16 The Fairway, Aldwick Bay Estate.

AW/137/17/HH

“Single storey extensions for bedsitting room & additional utility room”

EXISTING ELEVATIONS

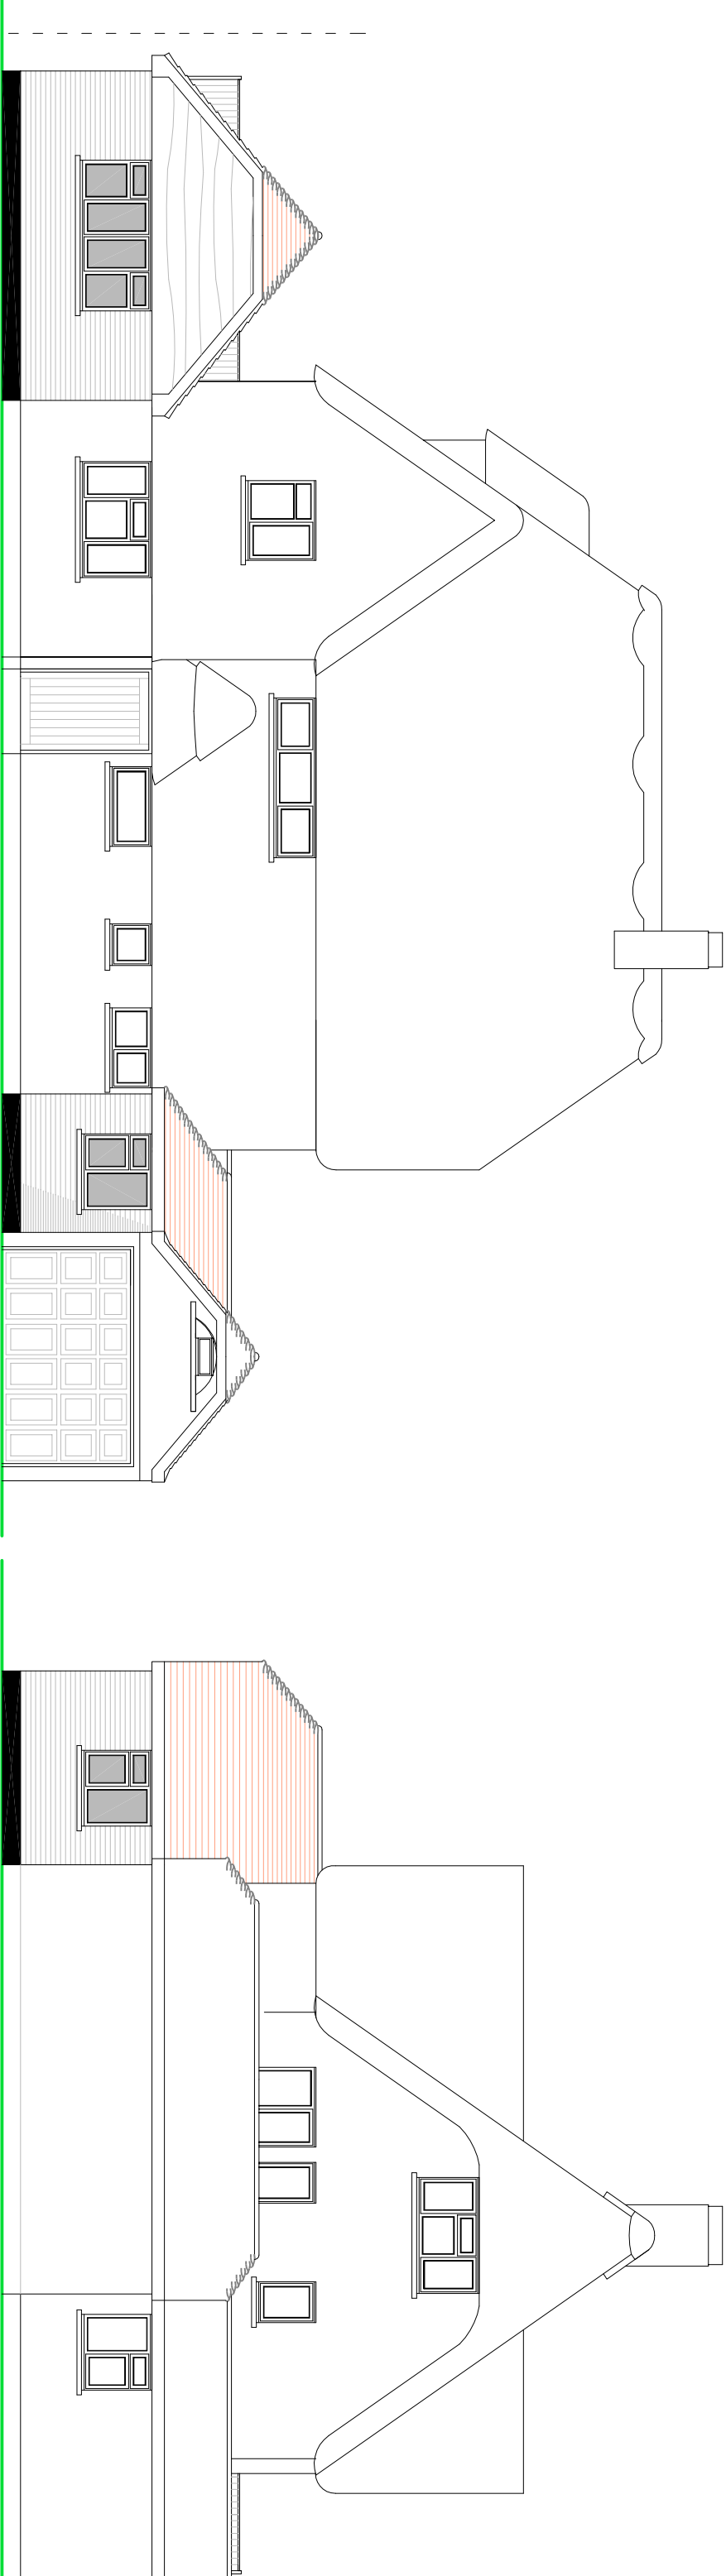
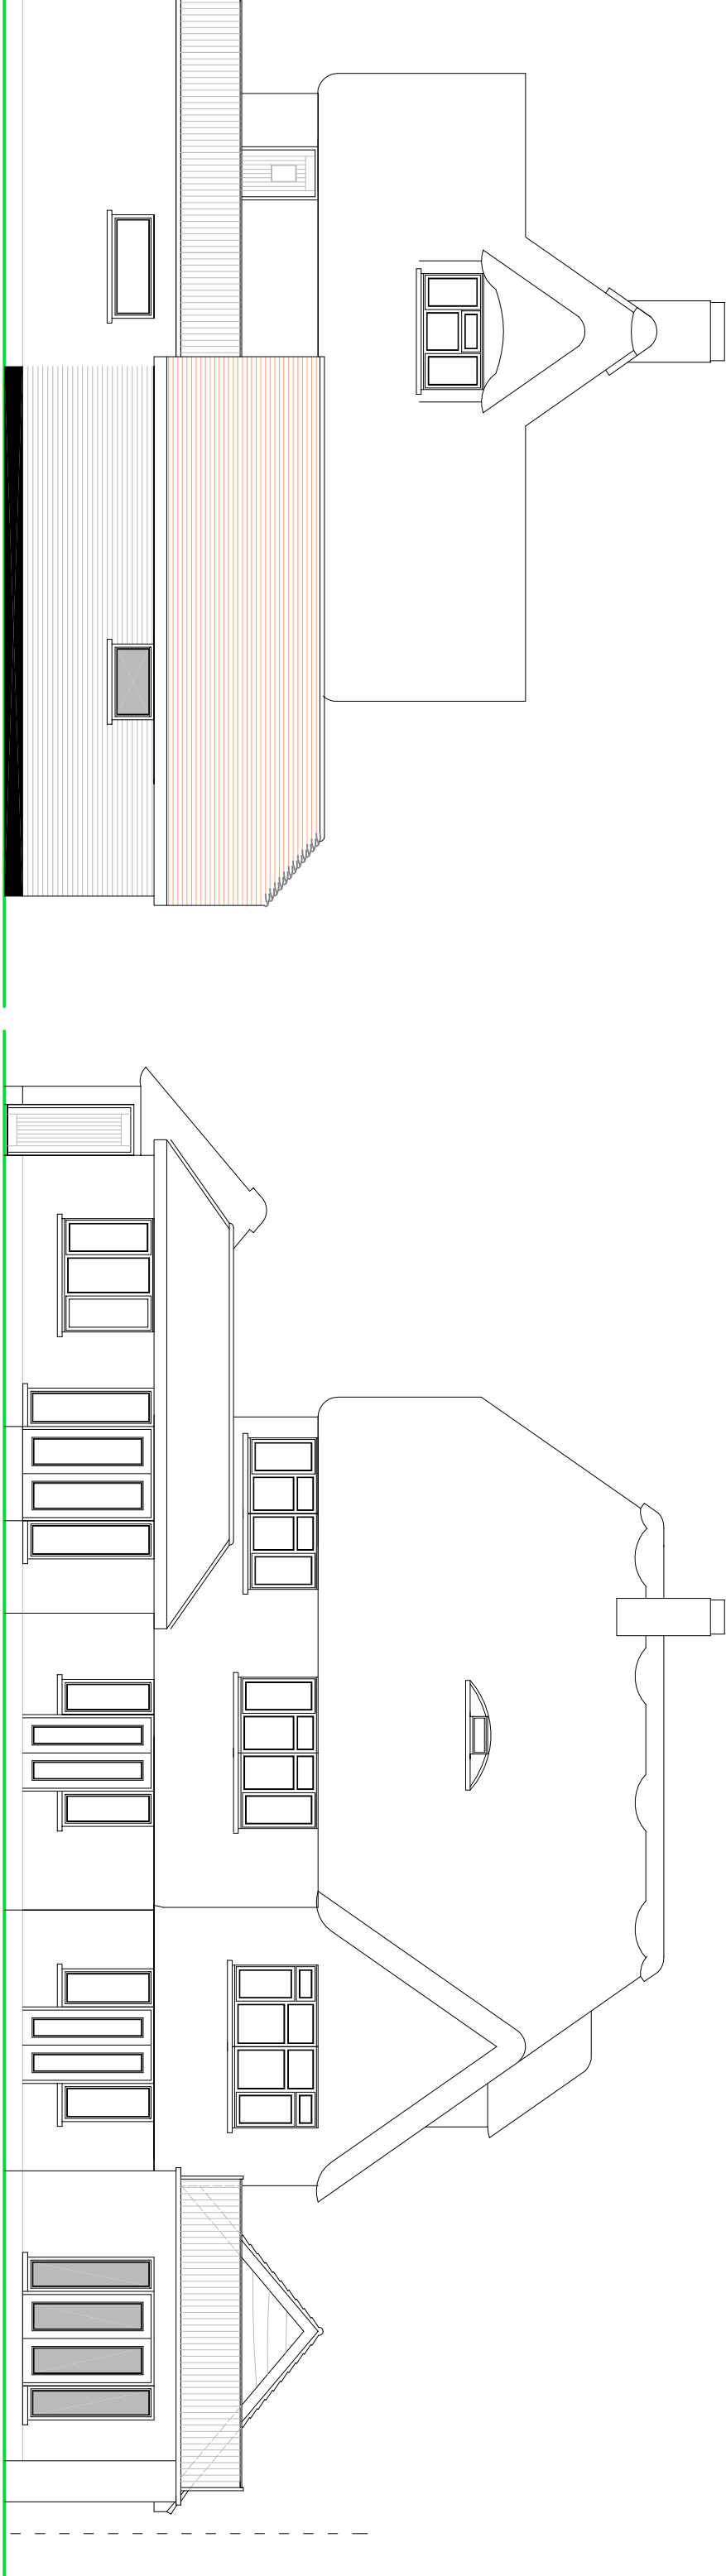
1. We have no objection to the plan size of the proposals.
2. The front elevation utility room extension roof form is bland and utilitarian and detracts from the front/street elevation.
3. Materials as noted in the application to match in colour and texture the existing wall and roof materials and we welcome the bonnet hips shown (rather than the half round).
4. With extensive works proposed it would be appropriate to include for a dedicated bin store area allowing bins to be stored away from street view.
5. We note that an existing Cordyline palm may be affected by the proposal.
